**Major Projects
Council Submission
Project Mars Data Centre (SSD-82052708) (Lane Cove)**

Environmental Impact Statement Response for the Project Mars Data Centre at 12 Mars Road, Lane Cove West.

PROJECT No.	DRAWING No.	REV
S24248	CI-0700	E

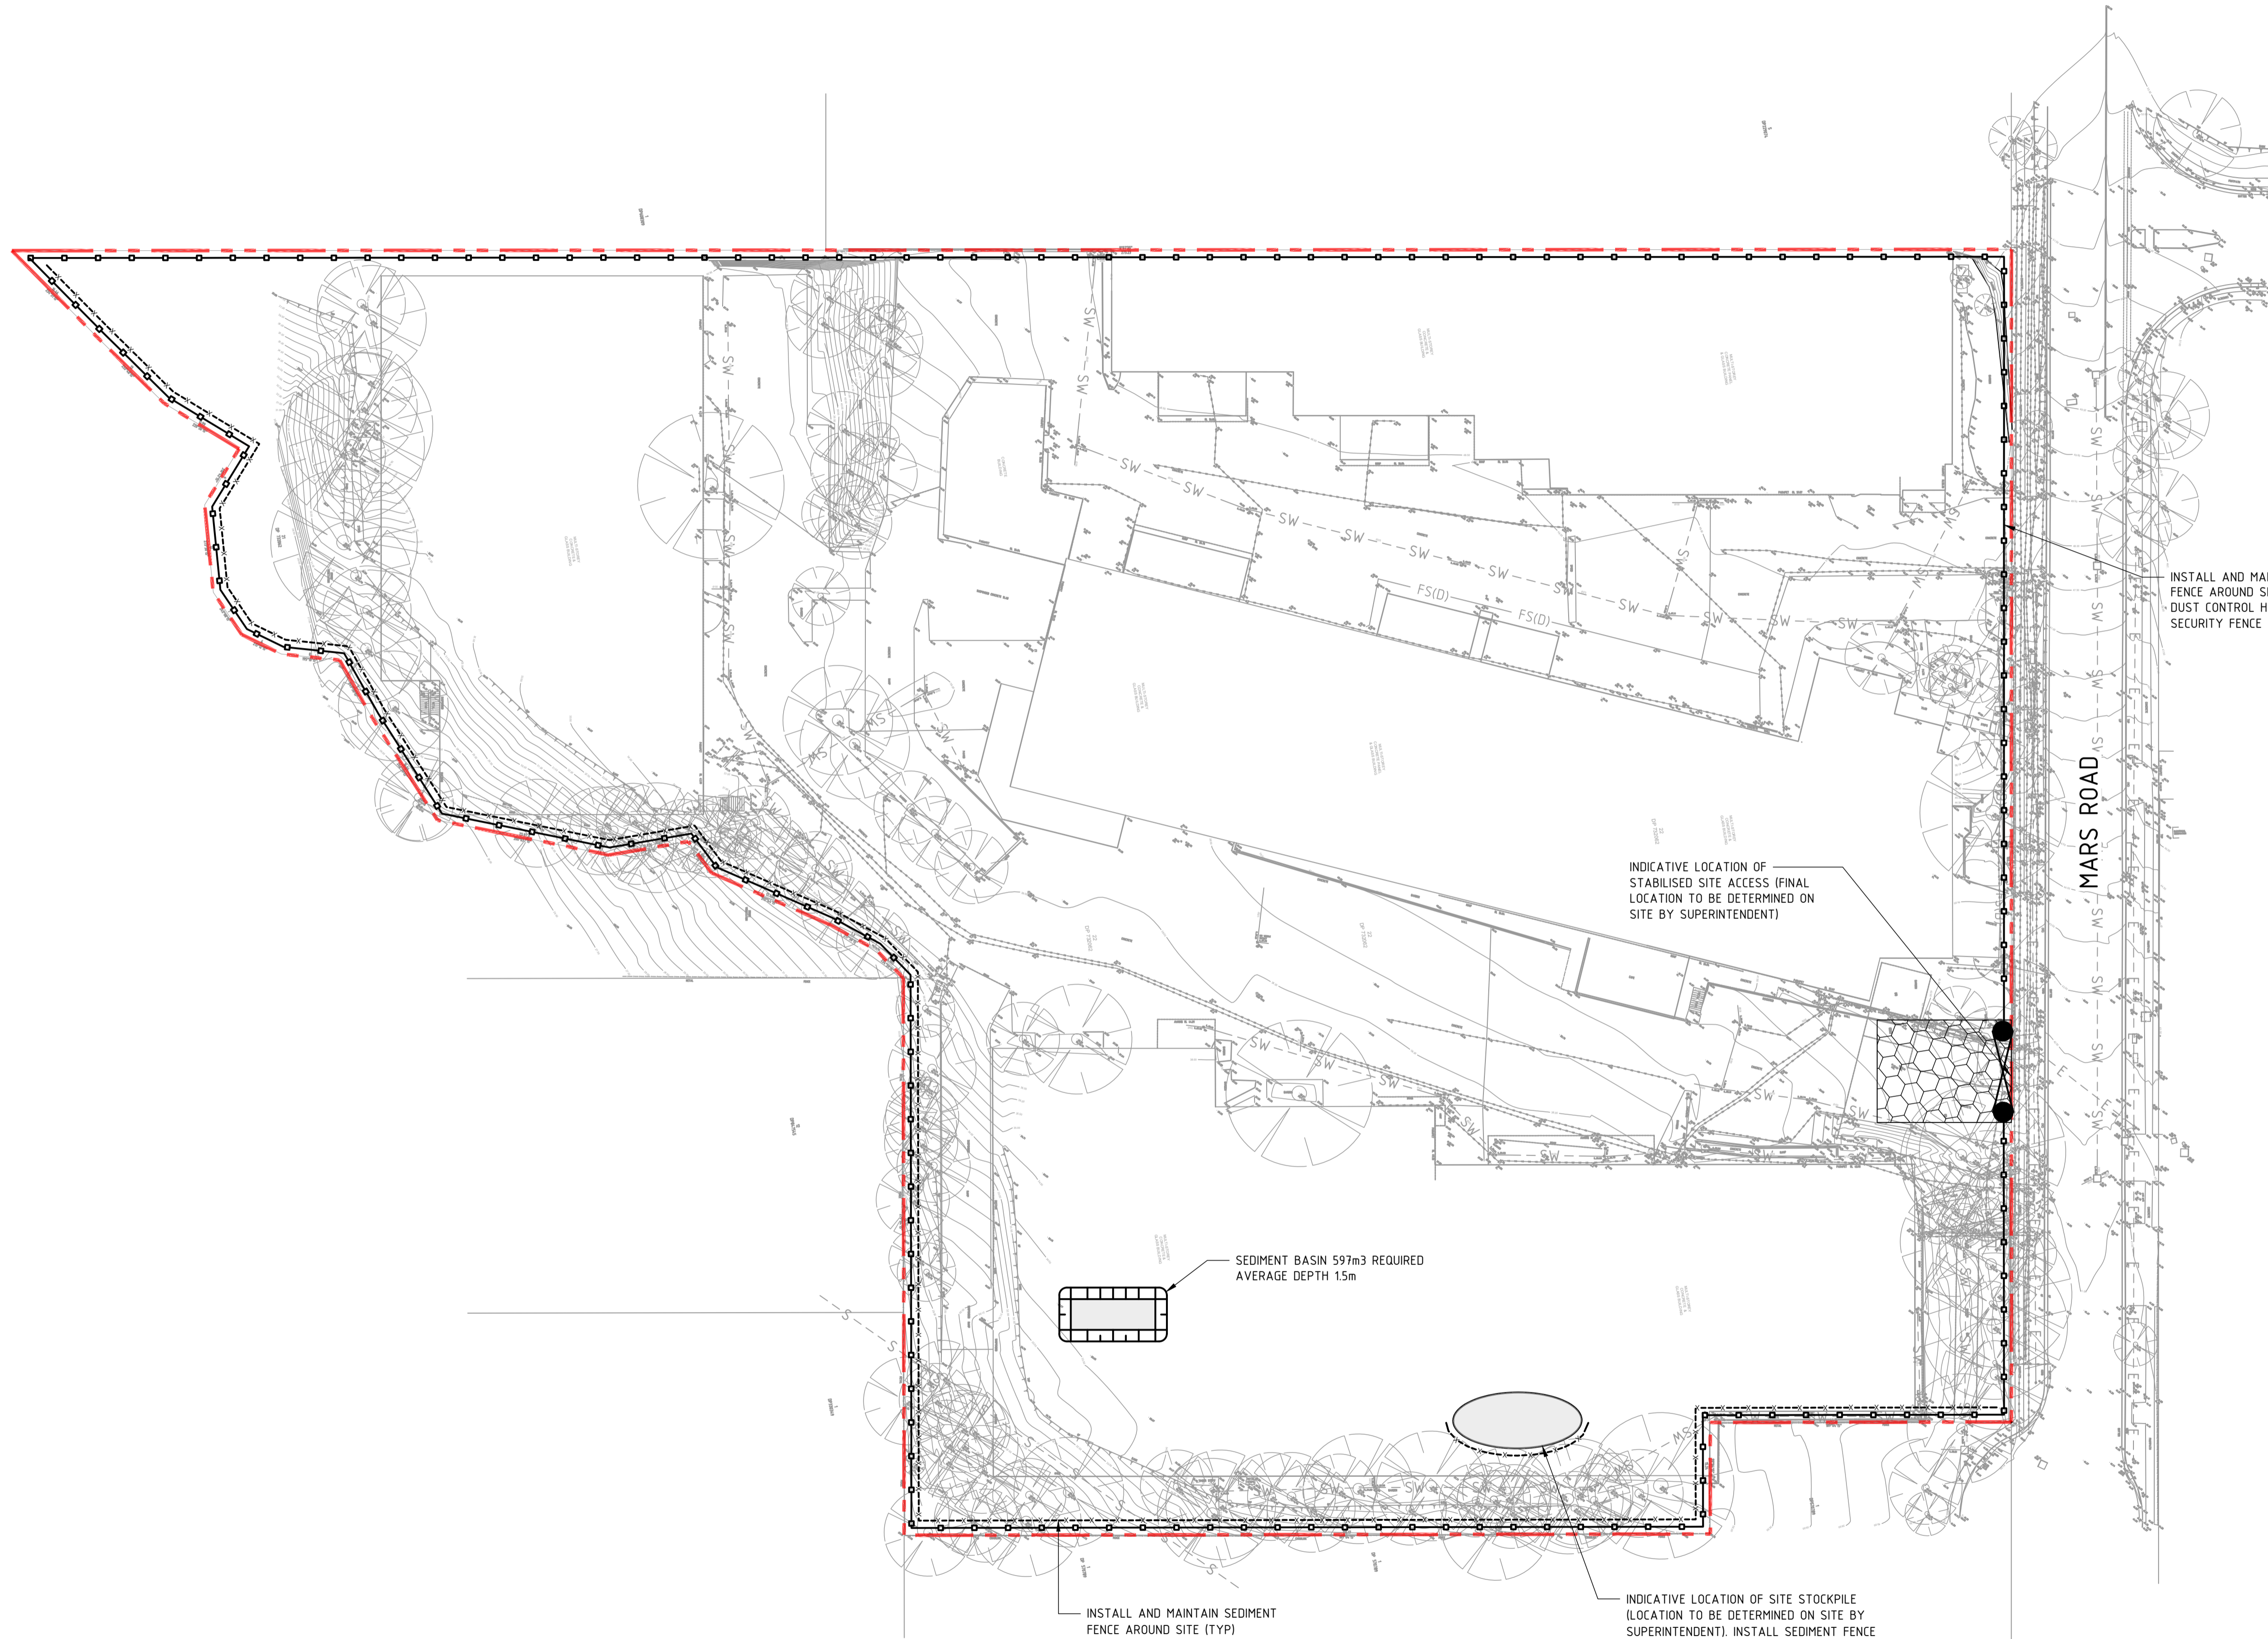
Further, Council raises significant concern with impacts to the ground water table (as established by PSM above), and potential contamination impacts which have not been considered in this assessment. Council also raises significant concerns with the proposed sediment and erosion controls. The proposed controls are inadequate for ensuring the protection of adjoining sites during the construction phase of the development, this matter is detailed later in the Bushland section of this response.

# 1.9 Existing Trees to be Removed

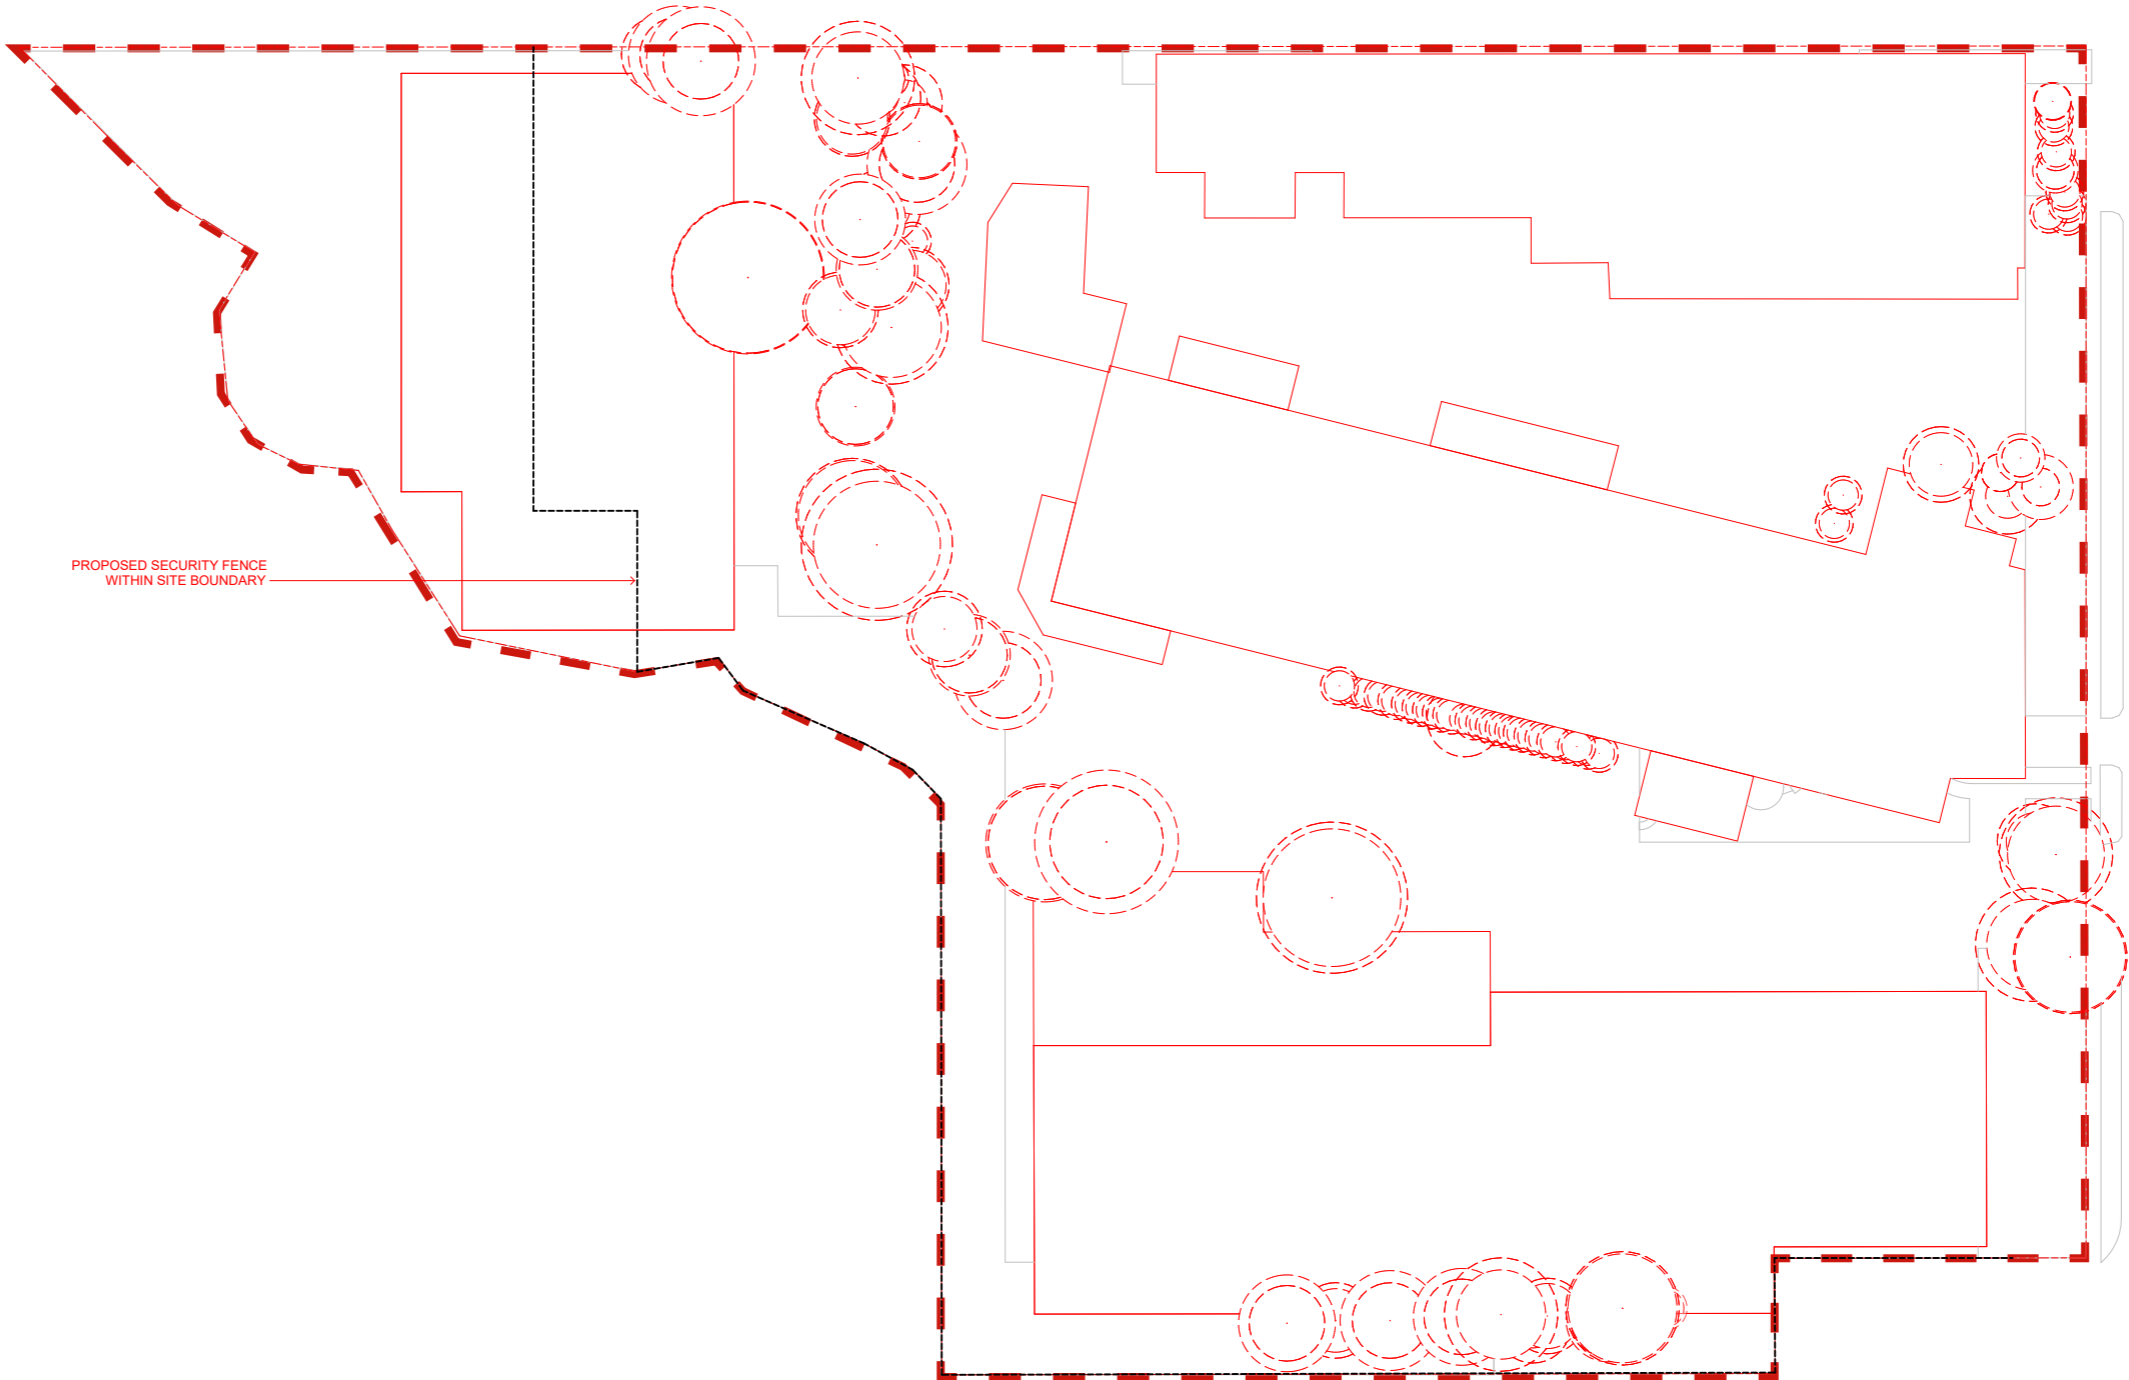
The VIA is misleading regarding the coverage provided from existing trees and the document fails to differentiate between the existing canopy being retained and the trees proposed for removal. This significantly affects the extent of screening proposed which is extensively relied upon in the VIA and Clause 4.6 Variation Request. This distorts the visual prominence of the proposed development and in particular the areas which breach the height development standard.
